**Red Text** = The El Paso County Comments Rev. 1

**Green Text** = The Engineer of Record answers on the El Paso County Comments Rev. 0 for Variance of Use project

## 1185 N Curtis Rd, Colorado Springs, CO 80930

PROJECT NAME:  
**VARIANCE  
OF LAND USE**

SHEET NUMBER:
S-1

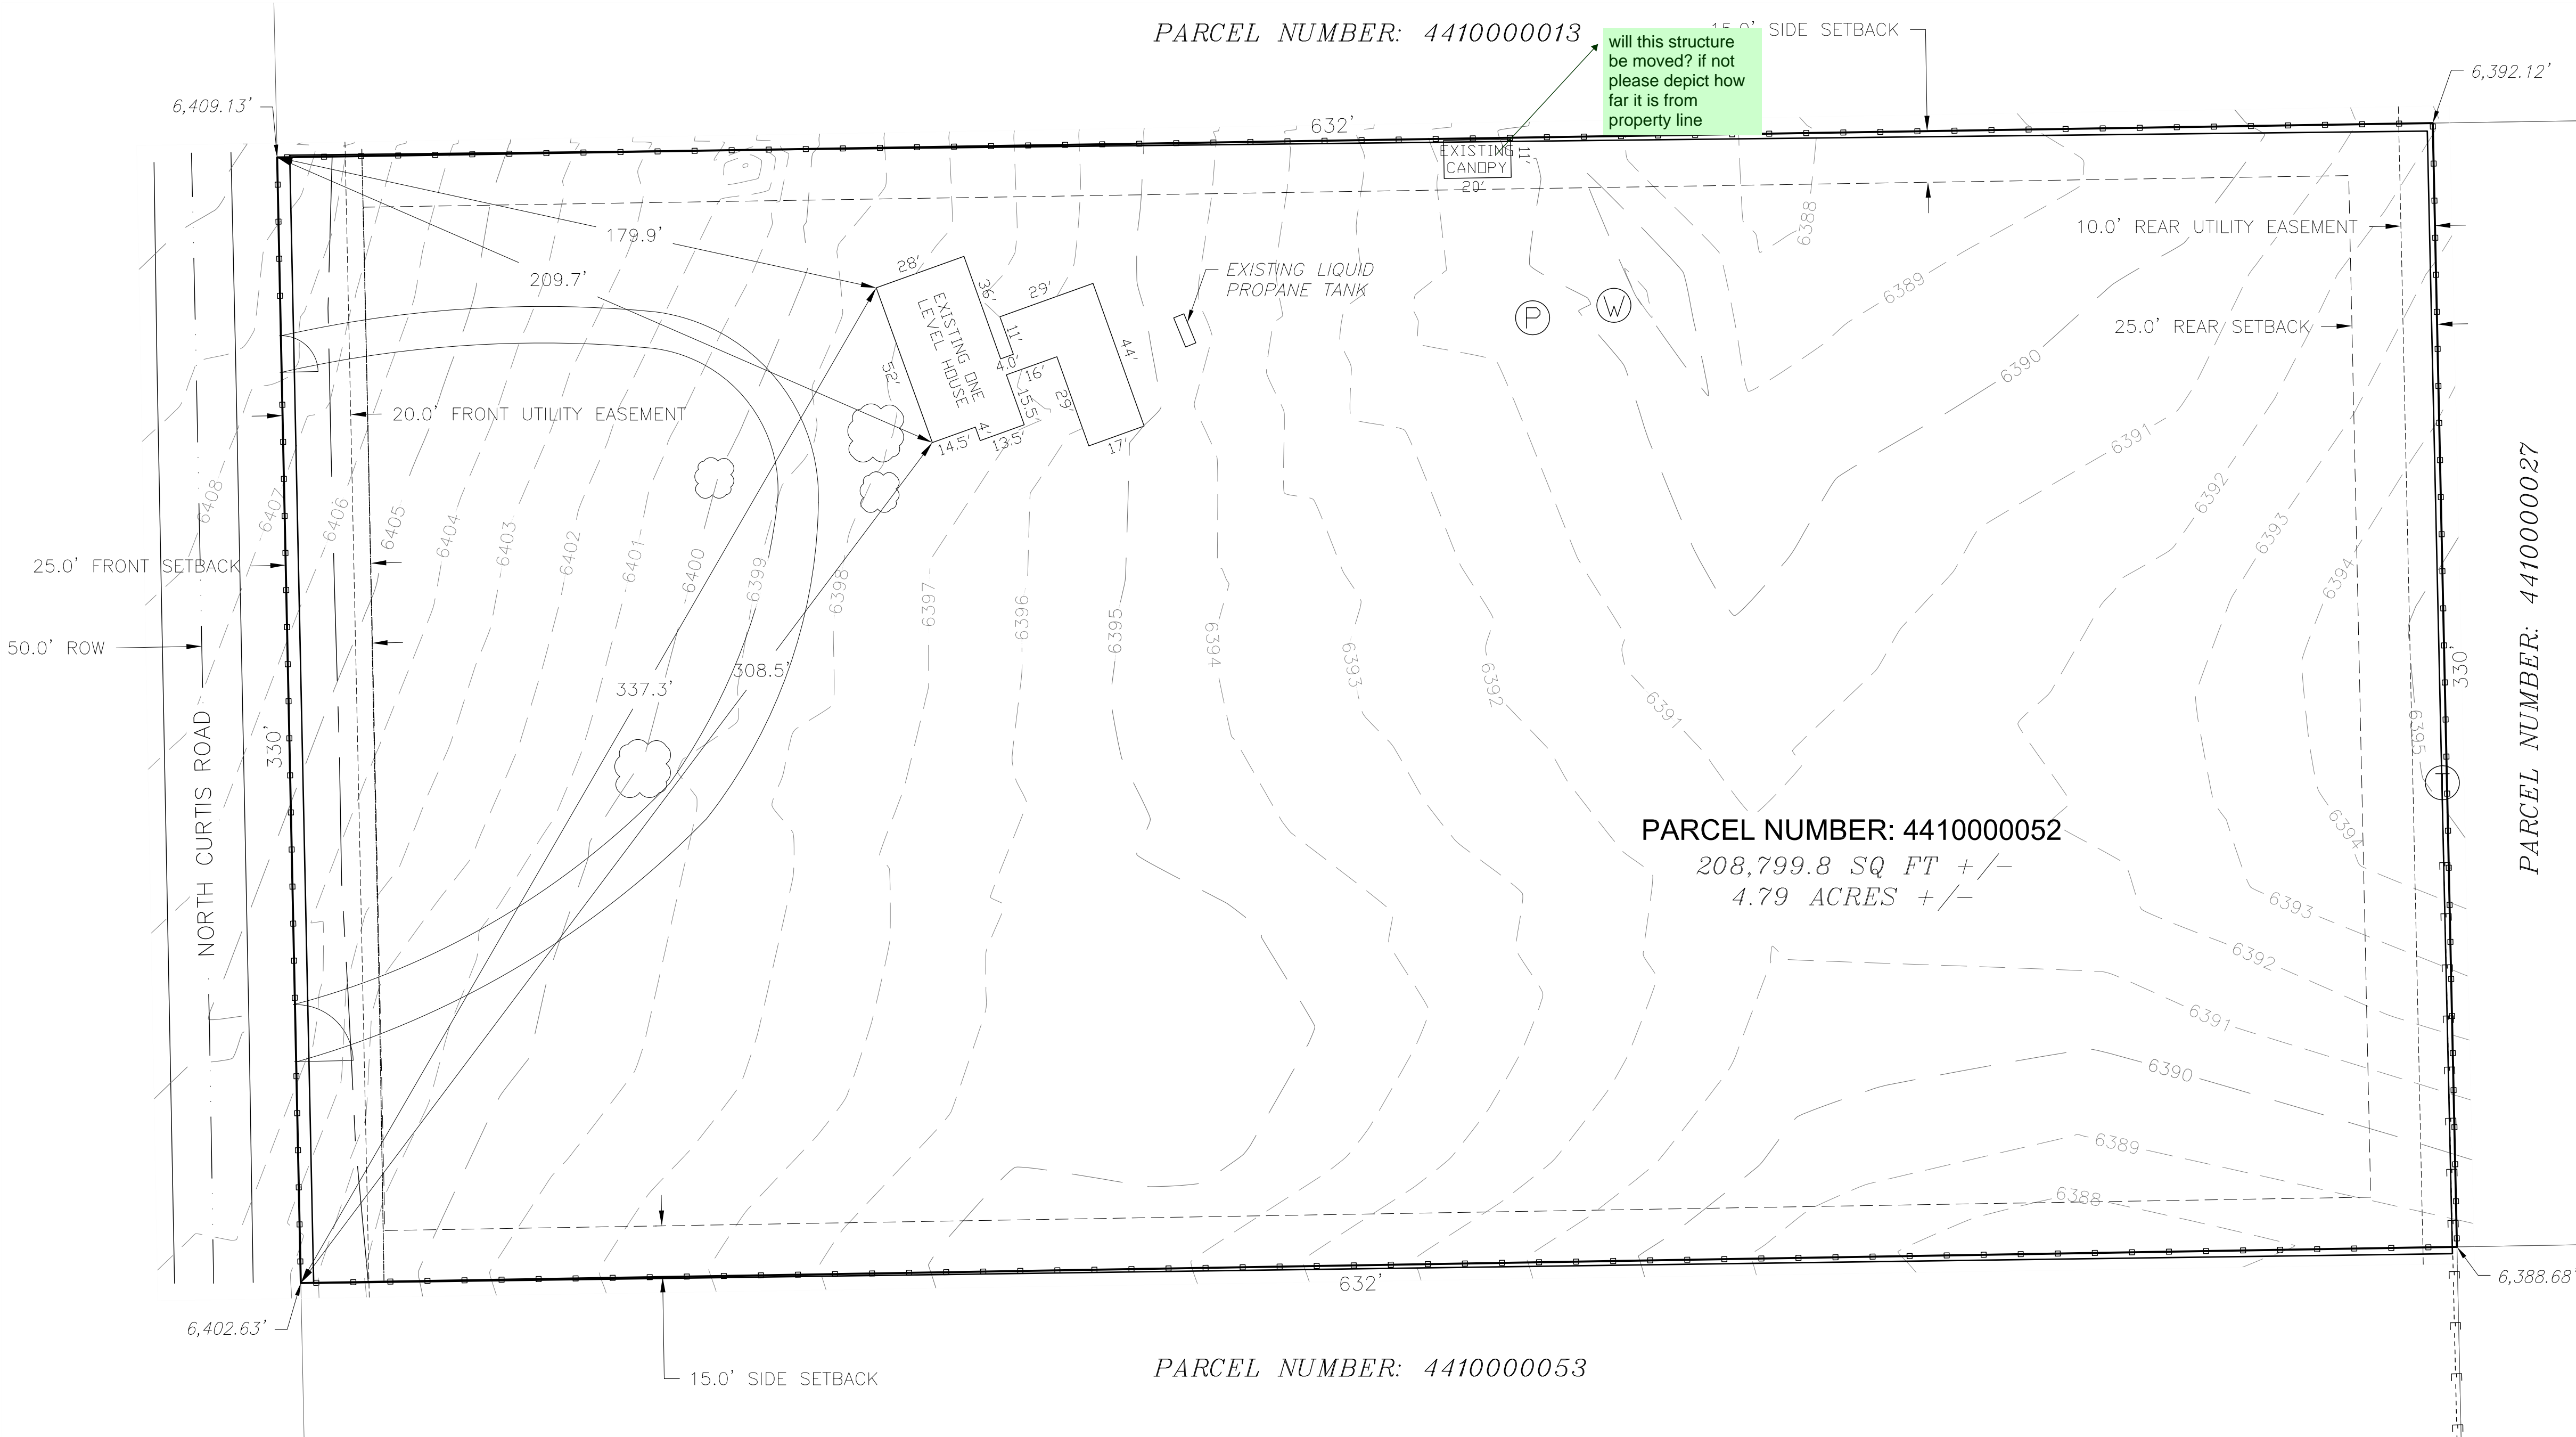
1. If there are no no-build areas or floodplains please specify  
✓ There are no no-build areas or floodplains.
2. What is the setback distance  
✓ The side setback distance is 15 feet. The Existing Canopy seats at the location as presented on Sheet #: S-1 before the client purchased the property. By the way, this structure will be moved to the new location as presented on Sheet #: S-2 with respect to the side setback.

SHEET NUMBER:
S-2

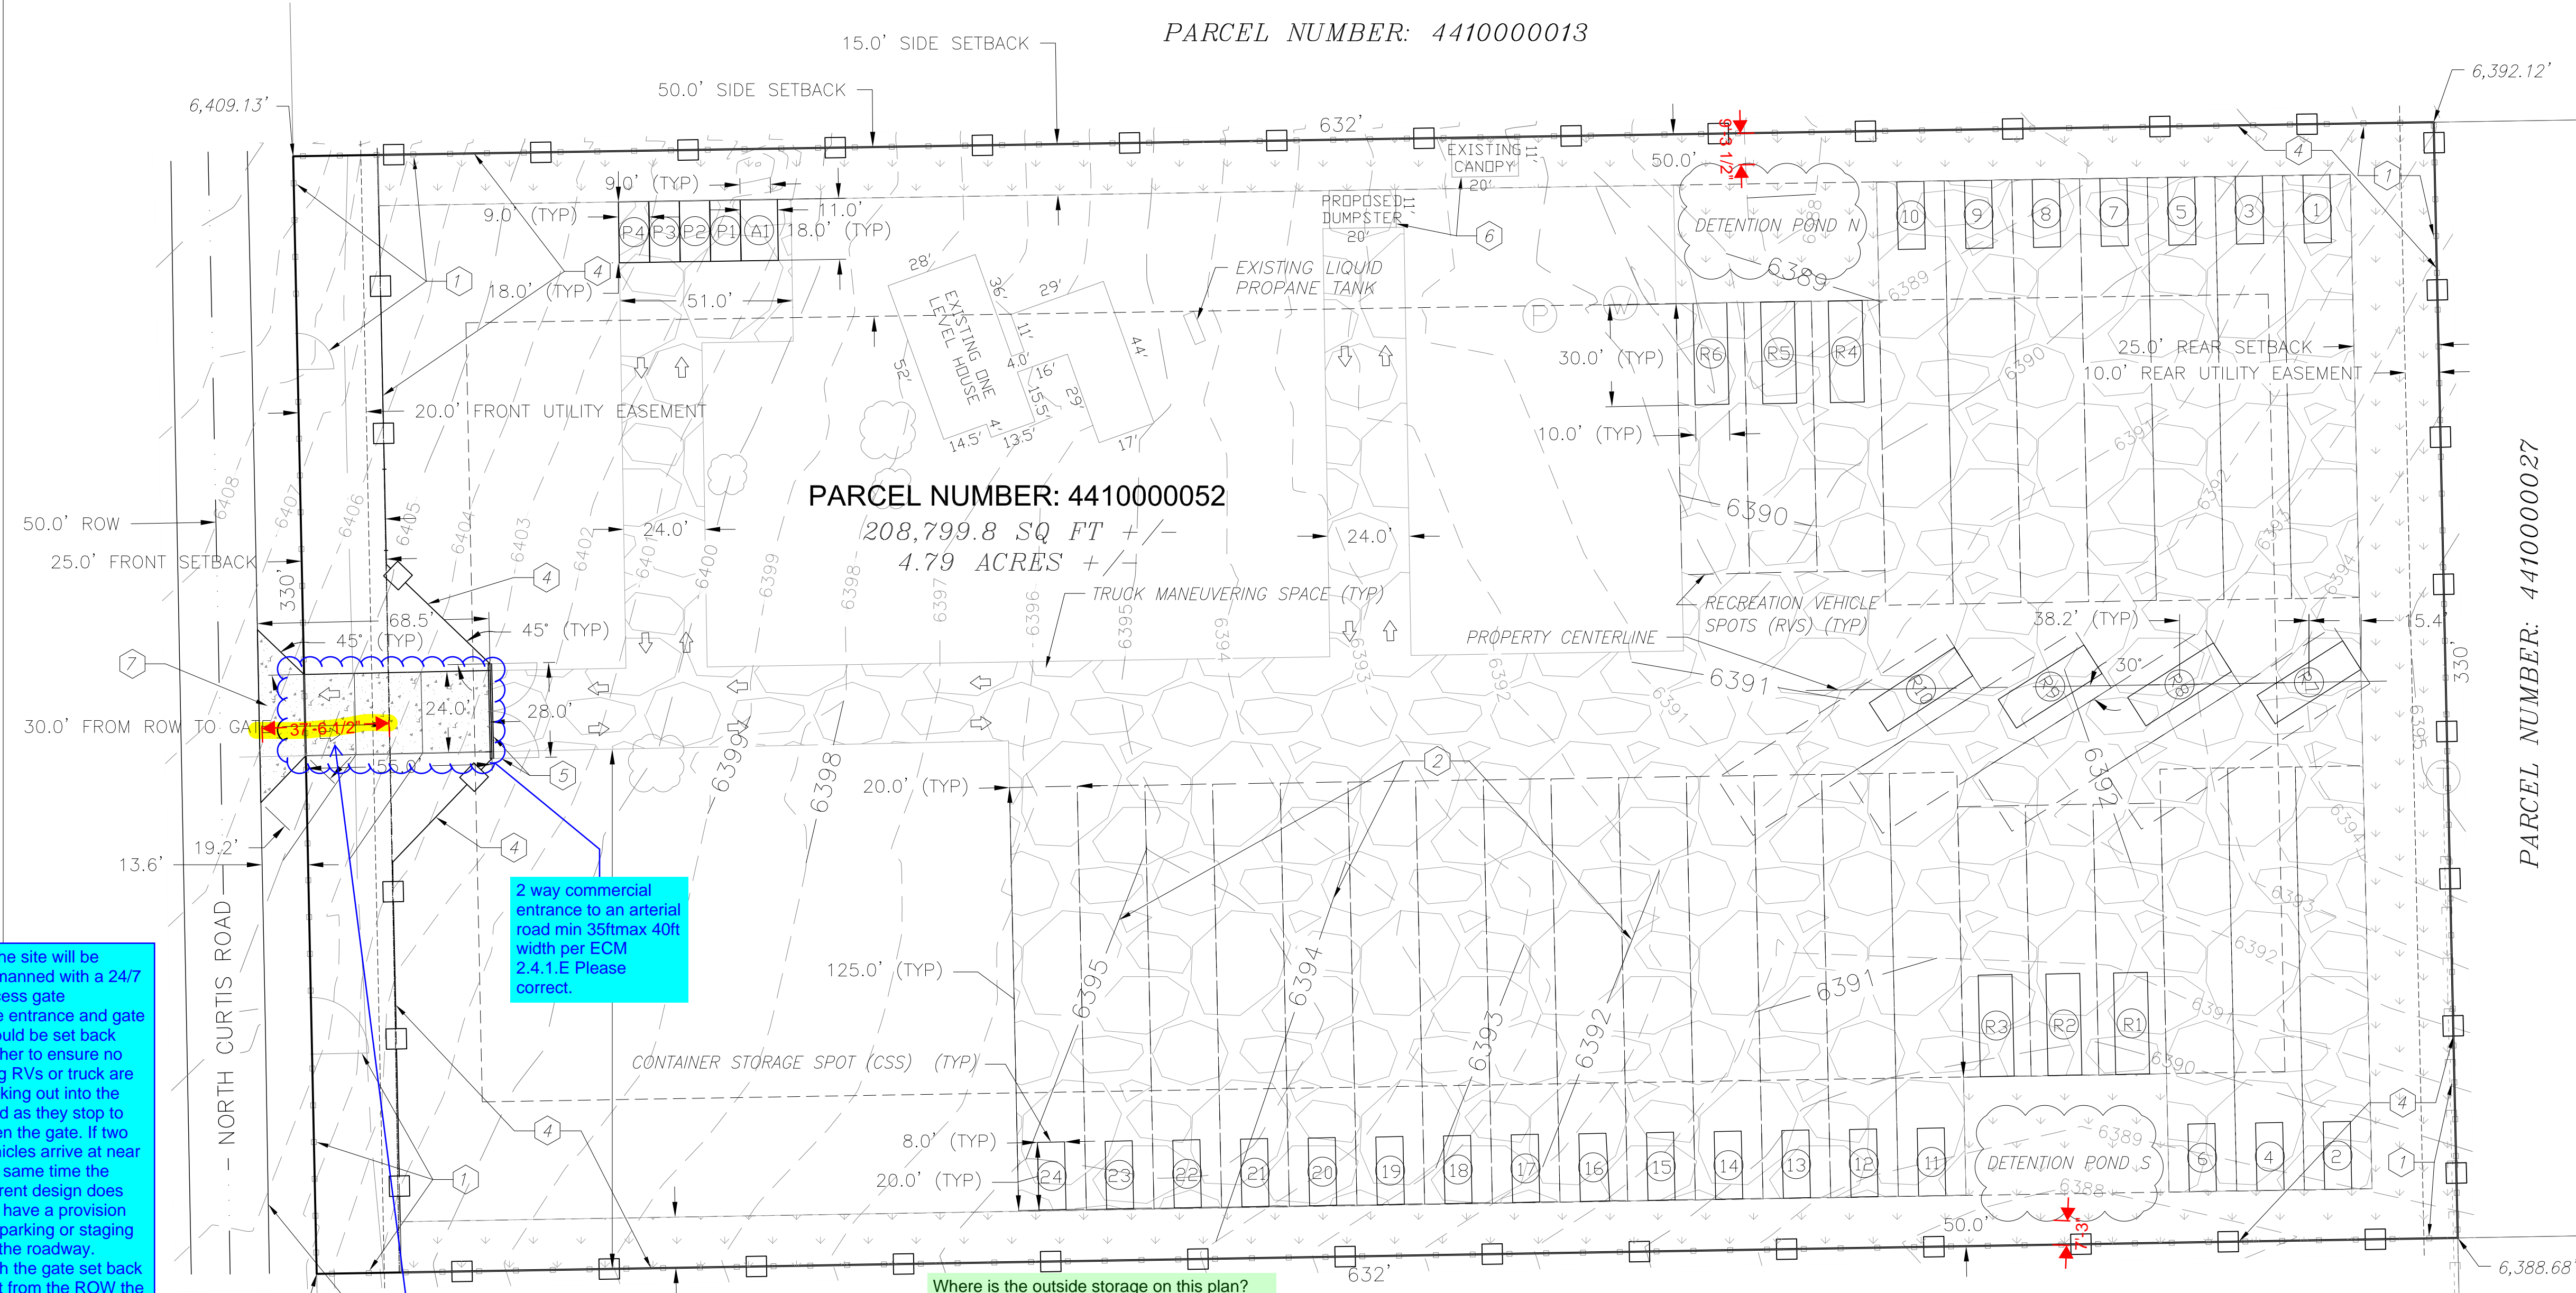
7. 2 way commercial entrance to an arterial road min 35ft max 40ft width per ECM 2.4.1.E Please correct.  
✓ Corrected, as presented on Sheet #: S-2
8. Specify material type  
✓ Corrected. Please see Legend on Sheet #: S-2.

9. Call out entrance surface material type for first 50ft either asphalt mat or concrete  
✓ The entrance surface material type called out is Number 7. Please see Schedule note number 7 on Sheet #: S-2.

10. Note: If the site will be unmanned with a 24/7 access gate. The entrance and gate should be set back further to ensure no long RVs or truck are sticking out into the road as they stop to open the gate. If two vehicles arrive at near the same time the current design does not have a provision for parking or staging off the roadway. With the gate set back 30ft from the ROW the longest vehicle could be ~37ft or it stick out into the ROW.  
✓ Corrected. The entrance gate is set back 40 feet from ROW.

✓ There is a very low probability that two vehicles arrive at the same time and the gate is closed. If that happens, they still have the opportunity to park side by side at the entrance driveway since that is 40 feet wide and more than 78 feet long.

TITLE:
 DETAILS

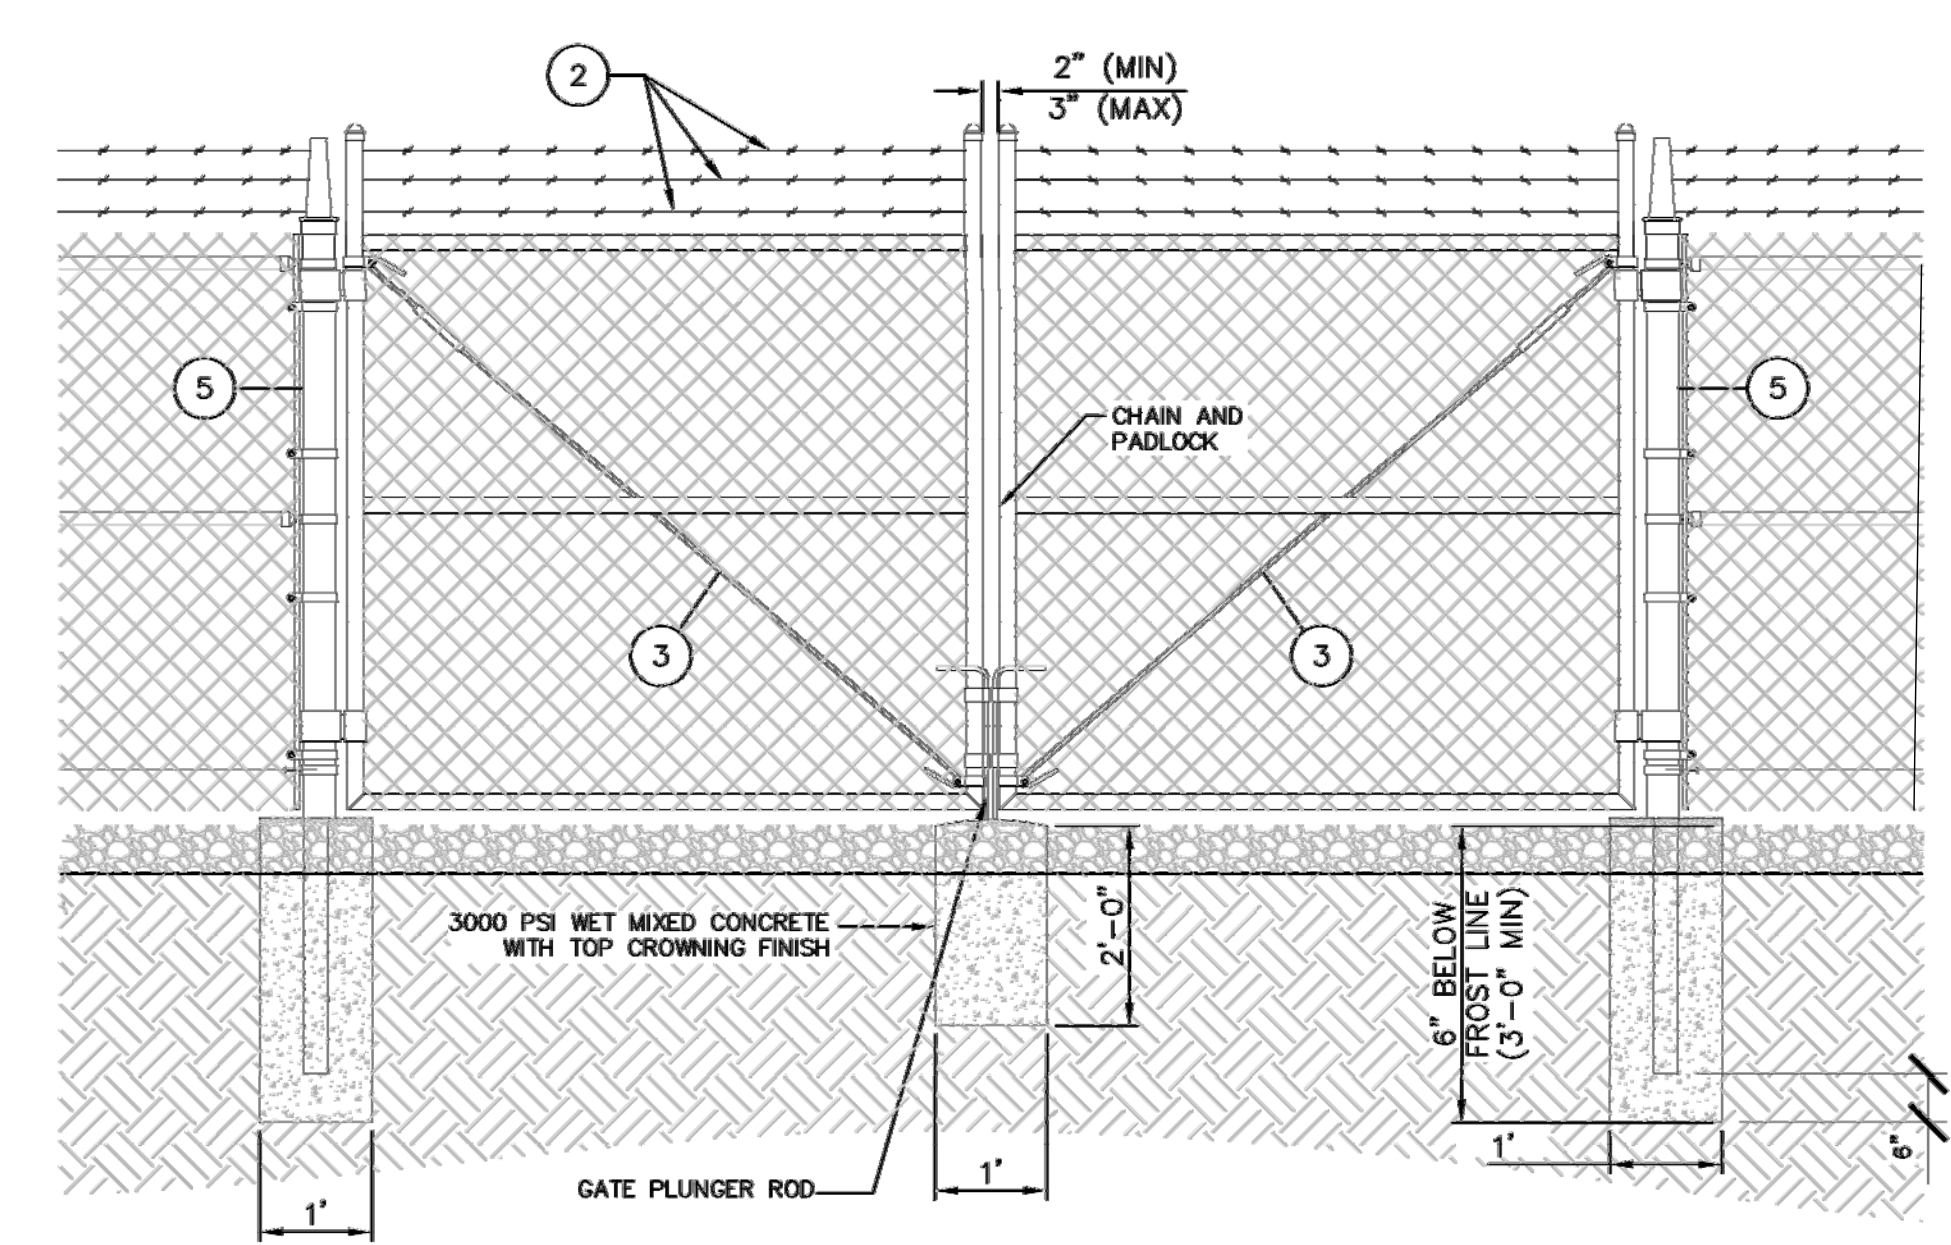
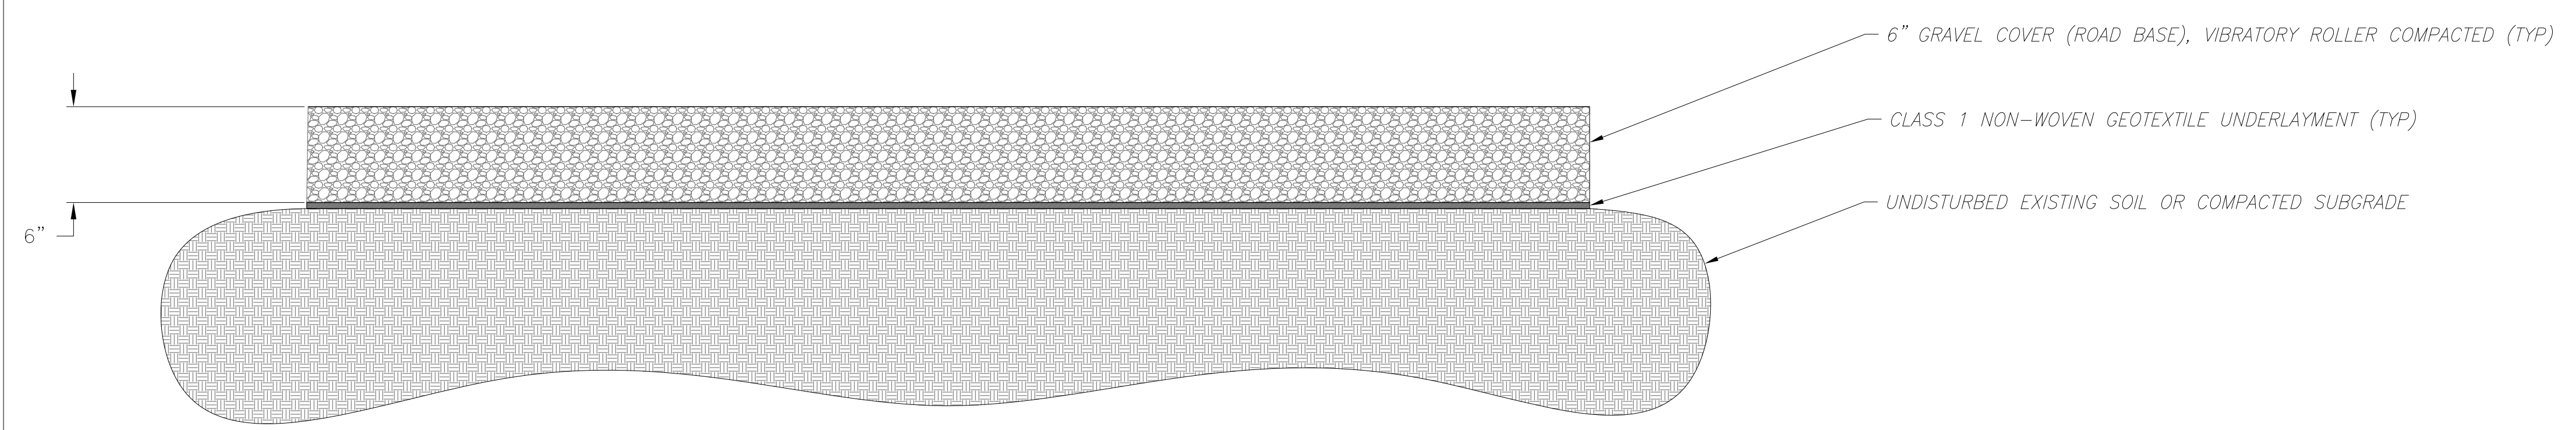
6. Anything over 7 ft will require a separate building permit  
✓ Corrected. There is nothing on the fence taller than 7 feet. Therefore, no need for a separate building permit as presented on Sheet #: S-3.
